Re 44\_1724\_BMH

Minor material amendment

**Re: DC/21/121428 land to the rear of 79 Belmont Hill, SE13 5AX**

Drawing Name  
**Proposed Roof Plan**

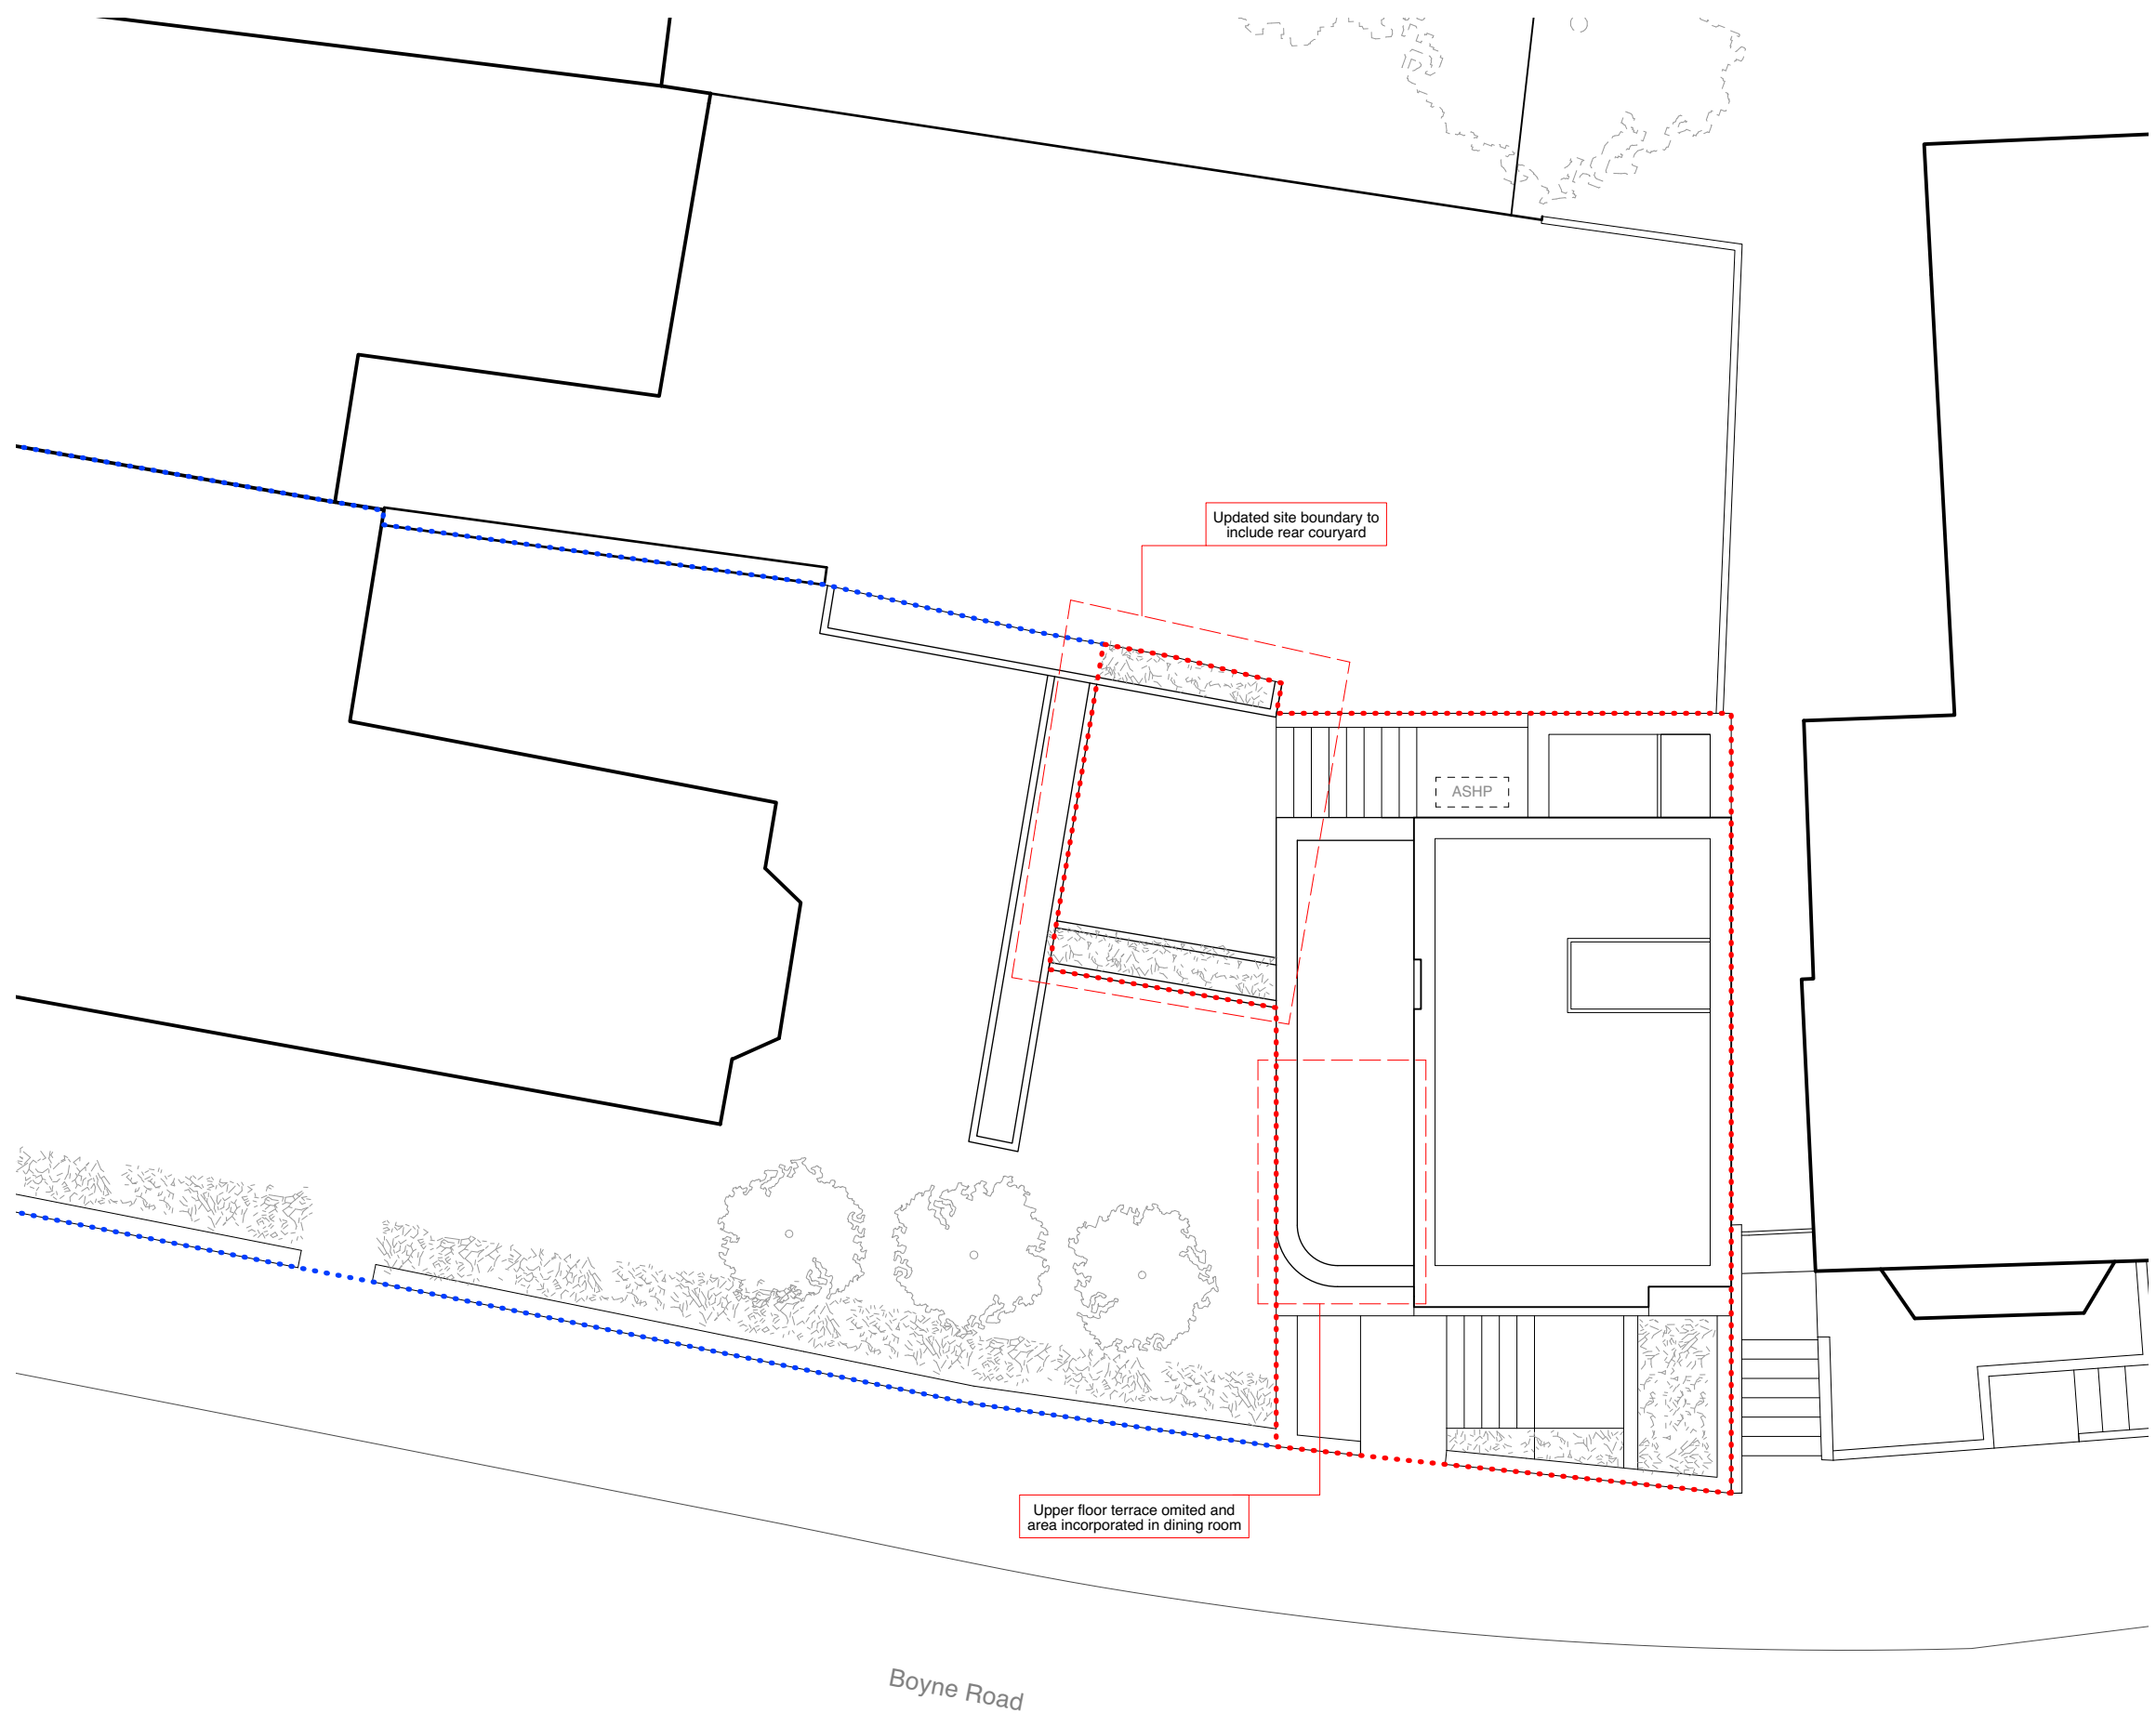
The amendment proposes to omit the upper ground floor terrace incorporating the space into the kitchen dining room. The omission of the 3.5 sqm terrace as external amenity space is positively offset by the proposed extension to the lower ground floor courtyard described above, resulting in a nett increase of 10 sqm of external amenity space. The internal area of the kitchen dining space would increase by 5.5 sqm, and the squarer proportion of the room would improve the usability of the space and flexibility in terms of furniture arrangement.

Externally the proposed amendments are minor. The location and amount of glazing is maintained, but wherein the consented design there are single panes of glazing enclosing the roof terrace, there are now fixed triple glazed units.

Drawing Name  
**Proposed Landscape Plan**

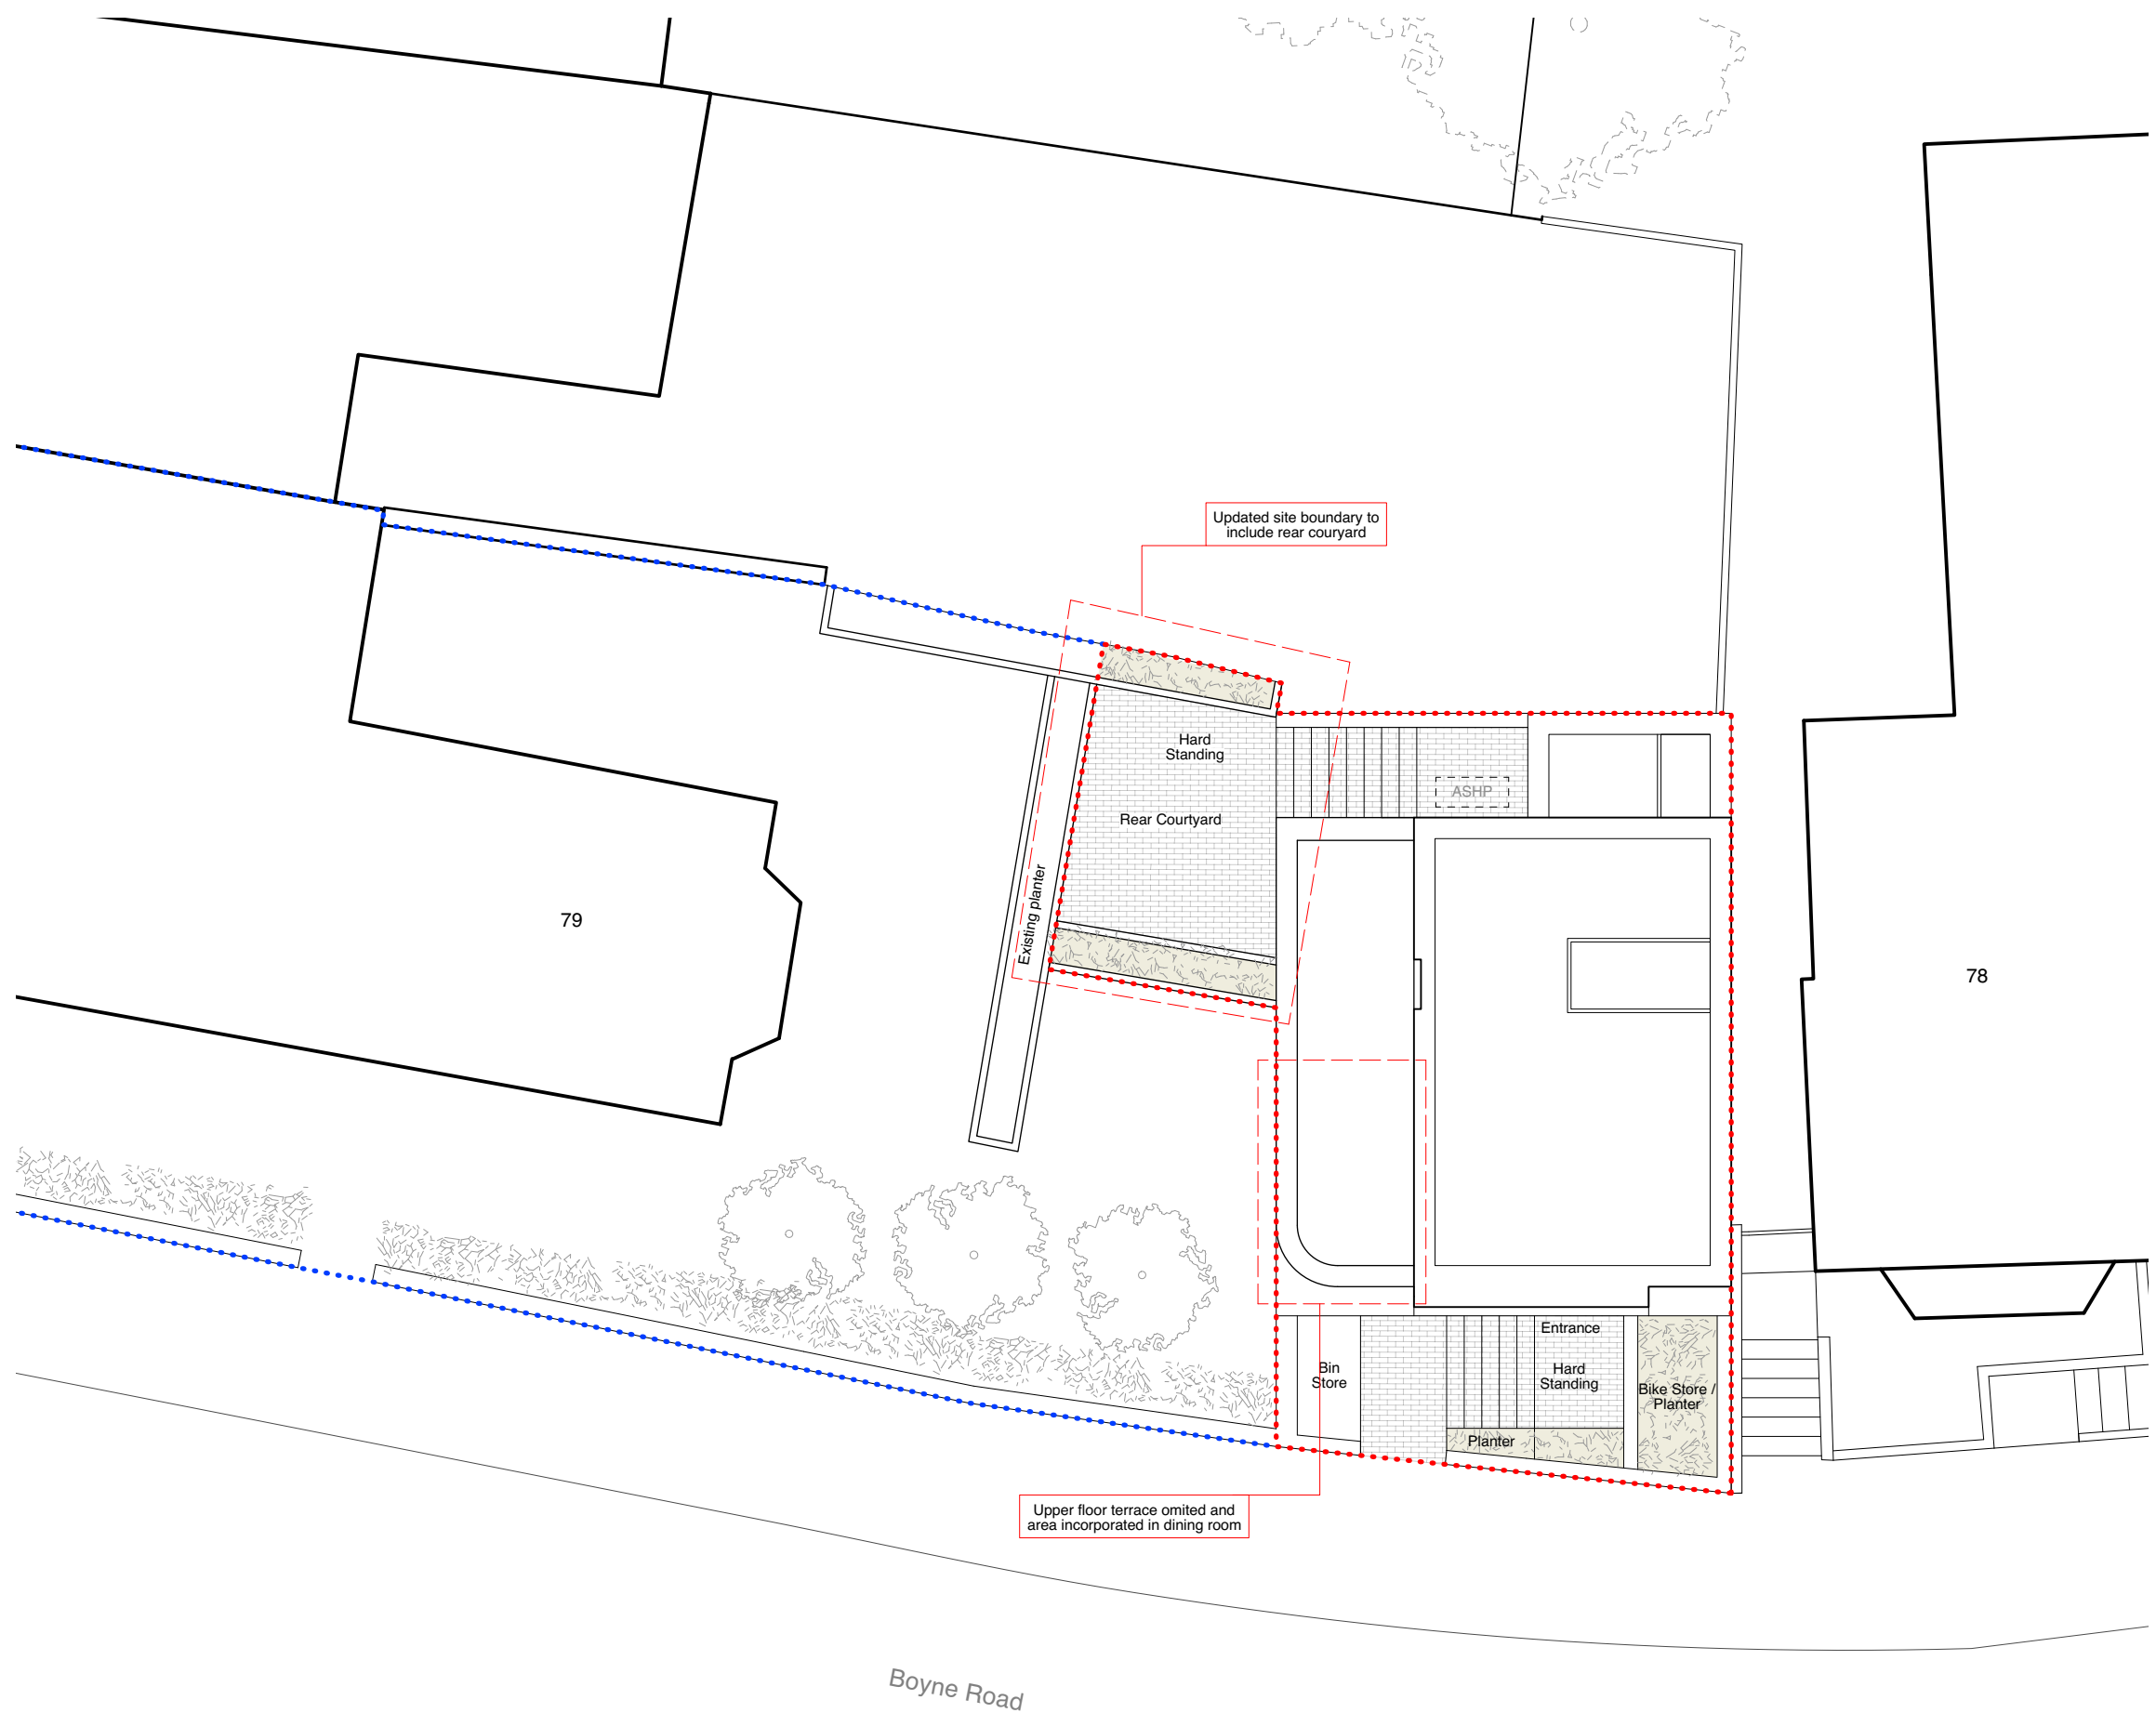
The amendment proposes to extend the lower ground floor courtyard along the southern edge of the property, providing an additional 13.5 sqm of external amenity space with a south-facing aspect. This extra space would come from the amenity space of Flat B, 79 Belmont Hill (also owned by the applicant), with Flat B retaining 25 sqm of private amenity space.

The proposed amenity space would be separated from the adjacent property to the south by an existing planter planted with Photinia hedge. It is proposed that this planter be extended to also form the eastern boundary of the proposed amenity space.
